DRB Application No.: 09DRB-70161 Project # 1004564
 Project Name: North Albuquerque Acres
 Agent: Forstbauer Surveying Co Phone No.: _____

CITY OF ALBUQUERQUE
PLANNING DEPARTMENT
DEVELOPMENT REVIEW BOARD

Project # 1004564
06DRB-01617 Major-Preliminary Plat Approval

FORSTBAUER SURVEYING LLC agent(s) for CONTINENTAL RETIREMENT HOLDINGS INC request(s) the above action(s) for Lot(s) 19-22, Block(s) 21, TRACT A, UNIT A, **NORTH ALBUQUERQUE ACRES**, zoned SU-2/O-1, located on PALOMAS AVE NE, between WYOMING BLVD NE and BARSTOW ST NE containing approximately 4 acre(s). [REF: 06DRB-00433, 05EPC-01808] (D-19)

Lot 22-A, Block 21
 being a replat of
 Lots 19 Through 22 Inclusive
 Block 21, Tract A, Unit A,
 North Albuquerque Acres
 within
 Elena Gallegos Land Grant
 Projected Section 19, T.11N., R.4E., N.M.P.M.
 City of Albuquerque
 Bernalillo County, New Mexico
 October 2006

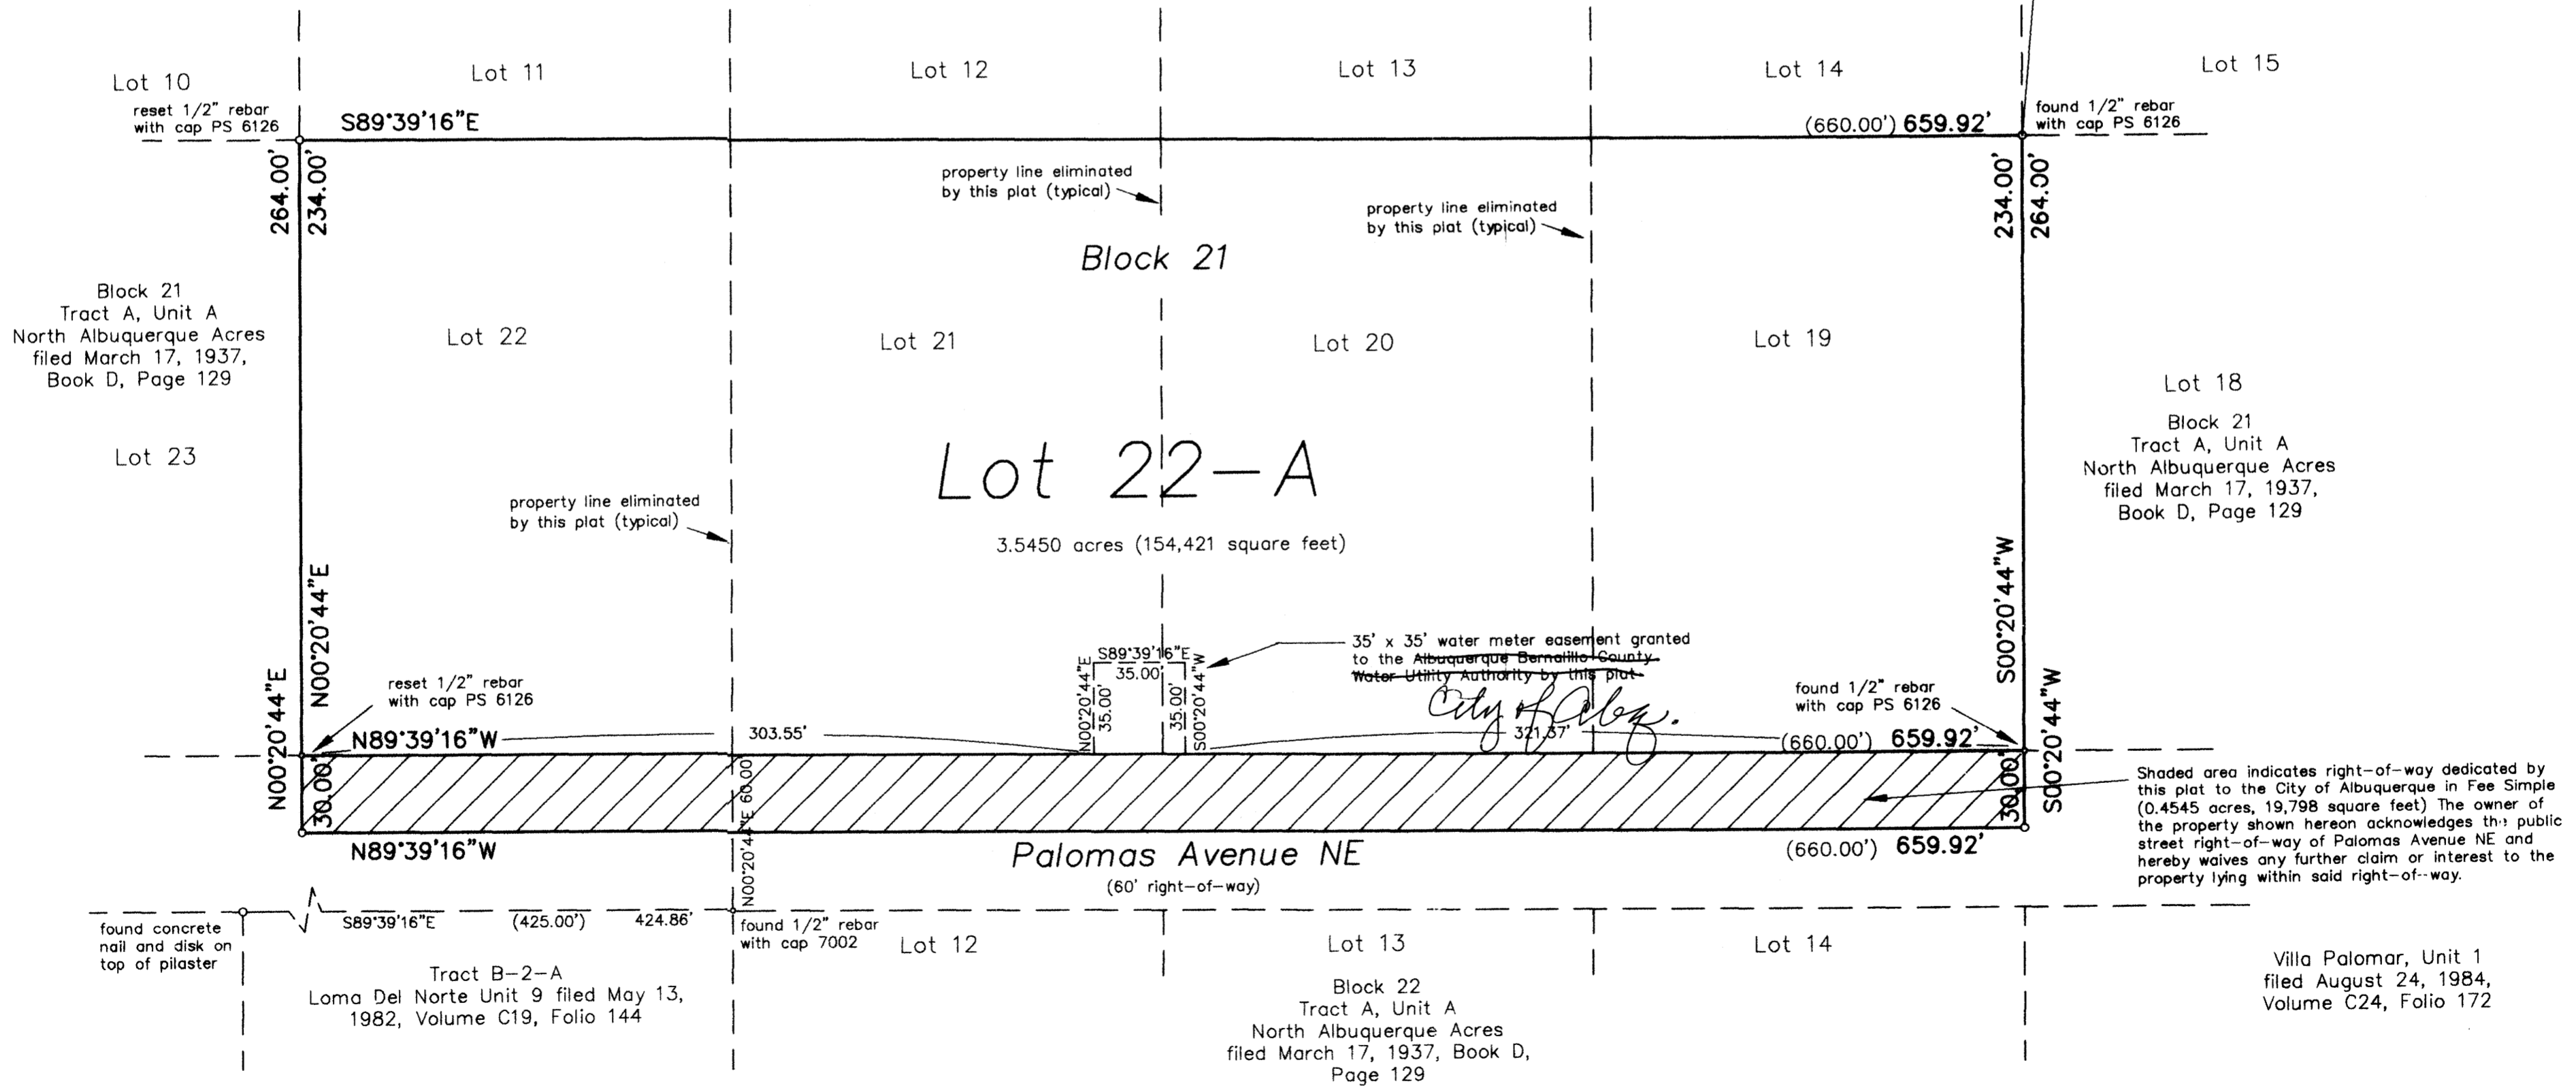
Water meter easement should be granted to City of Albuquerque, not the ABCWUA. Grading Plan must be revised to remove the detention pond from the water meter easement area.

The water meter easement should be granted to the City of Albuquerque not the ABCWUA.
